Application for Planning Permission for Works or Extension to a Dwelling

Development: First floor side extension, mansard roof extension with 2 x side dormers and installation of crossover.

Location: 25 Pevensey Road Bognor Regis PO21 5NS

DRAWING TITLE EXISTING GROUND FLOOR PLAN

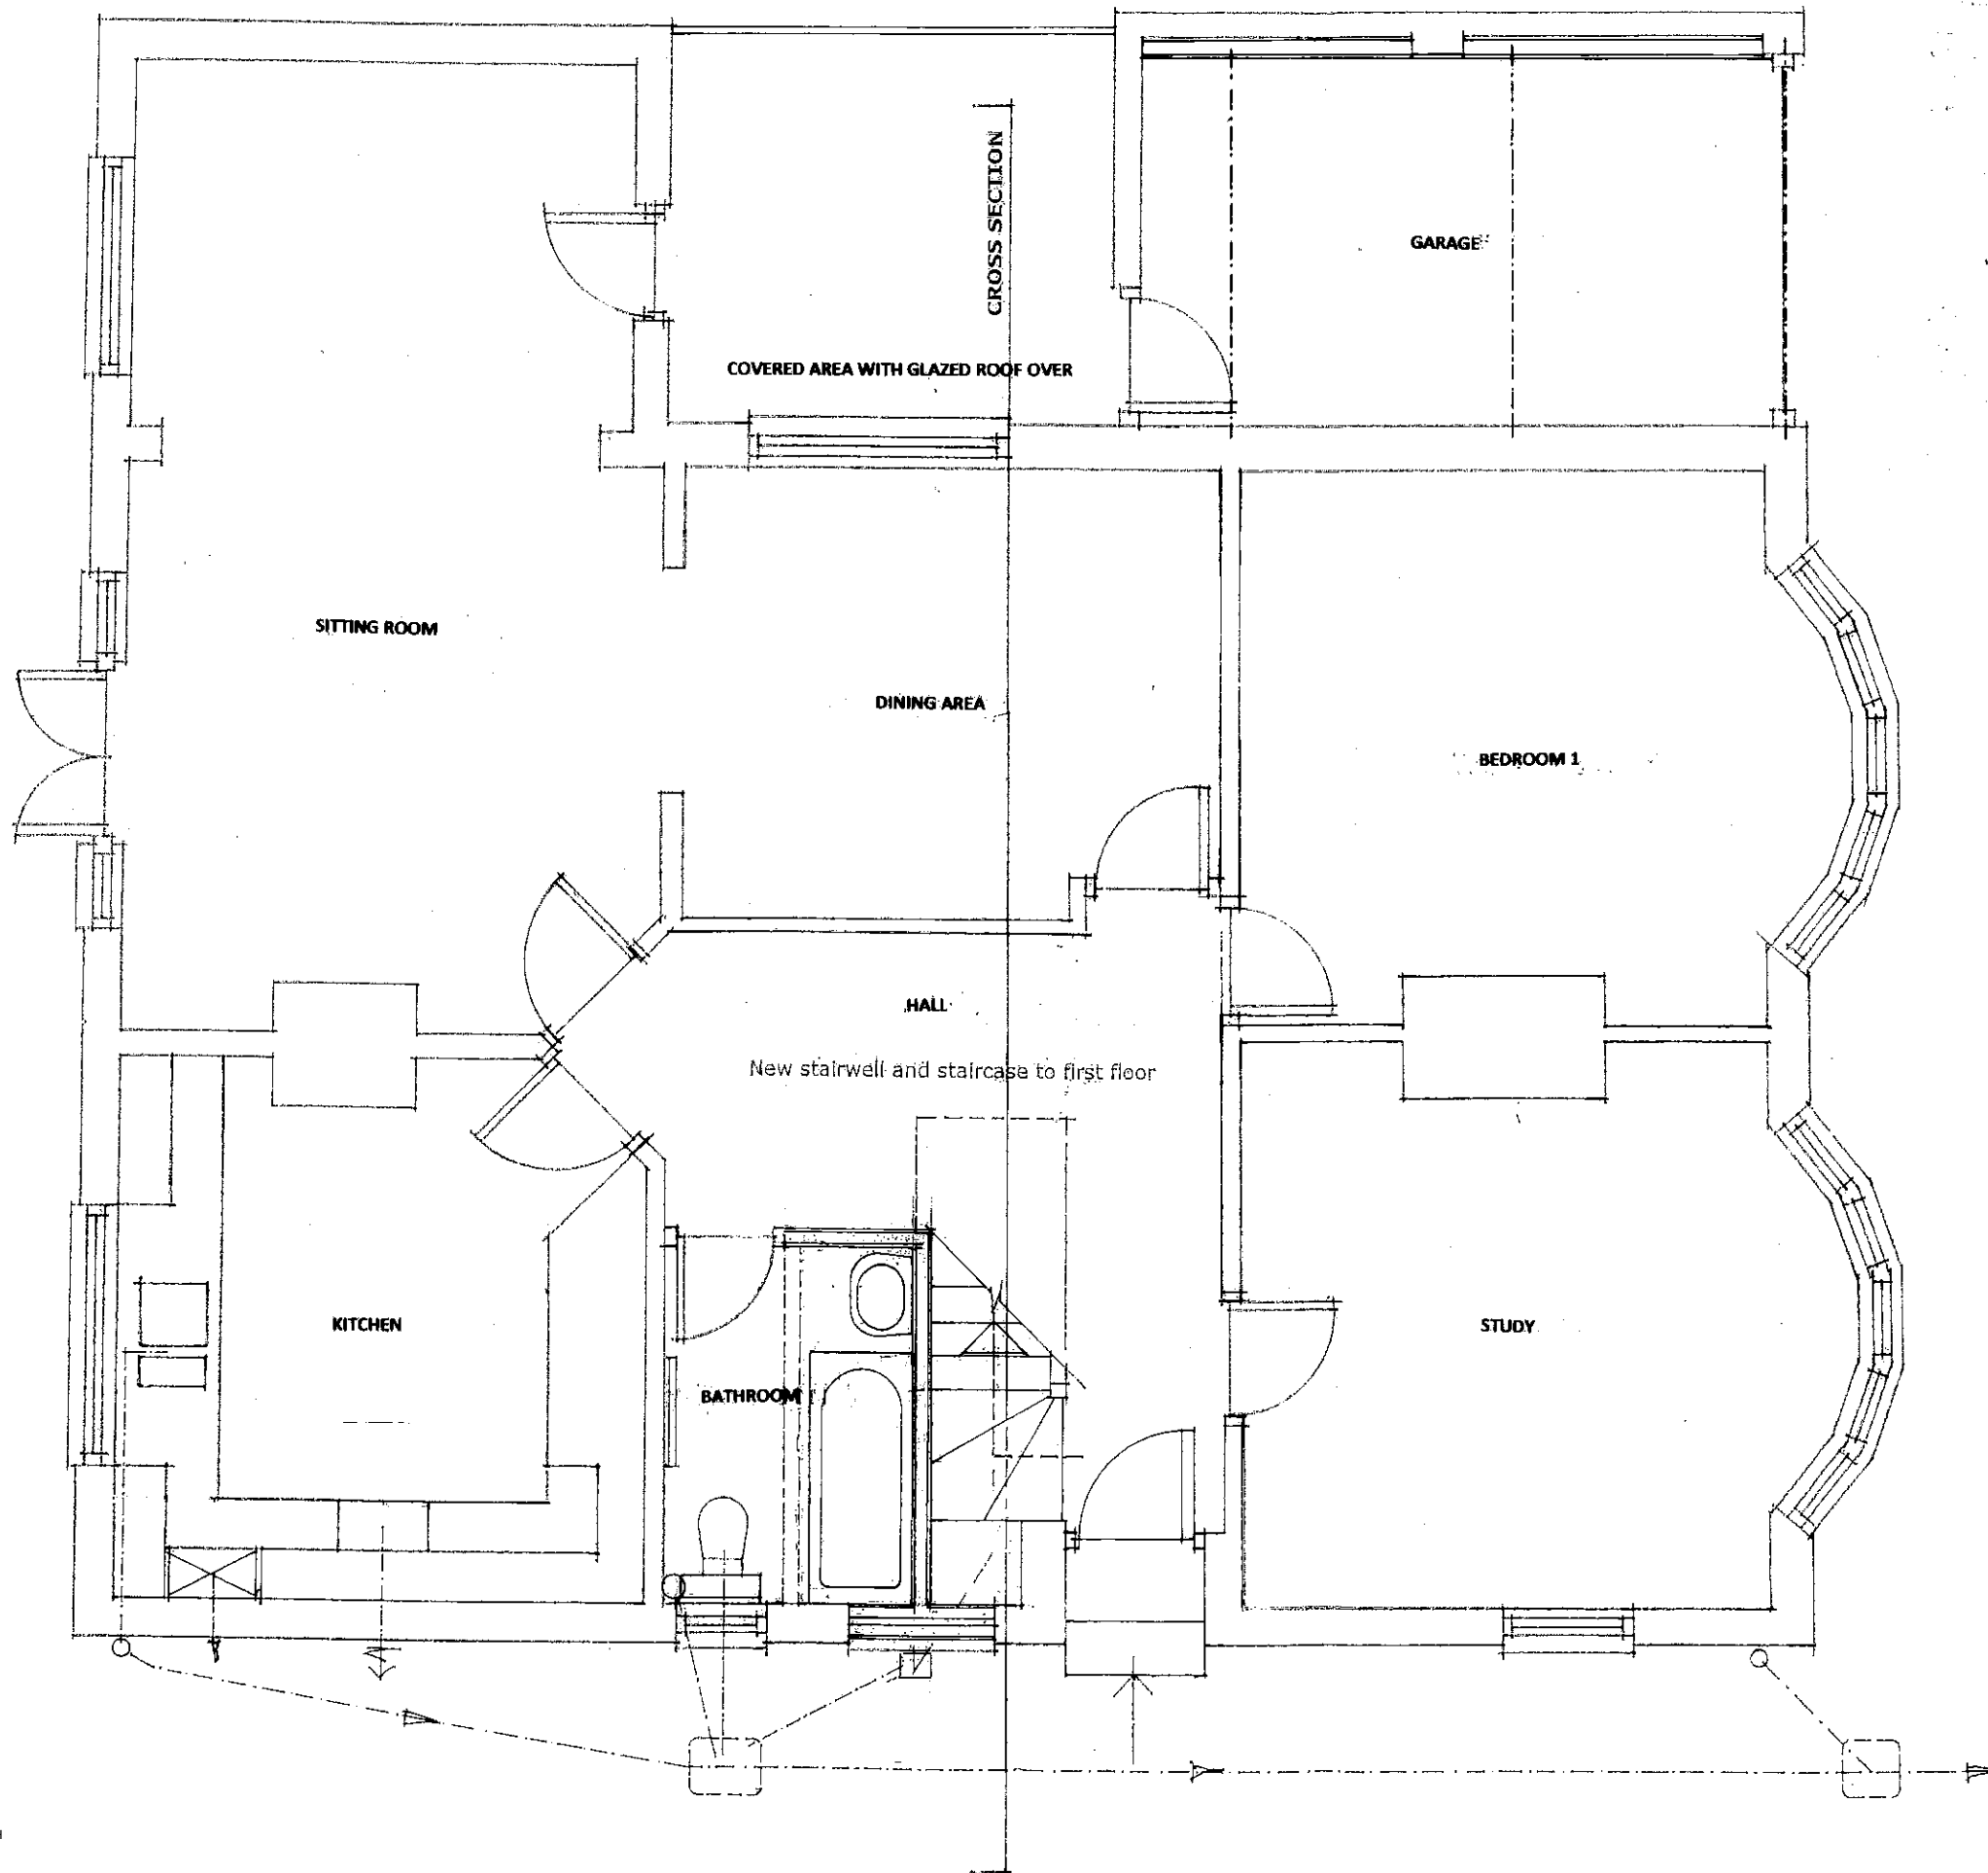
The window on the existing ground floor plan is missing from the existing and proposed east elevation. Please amend.
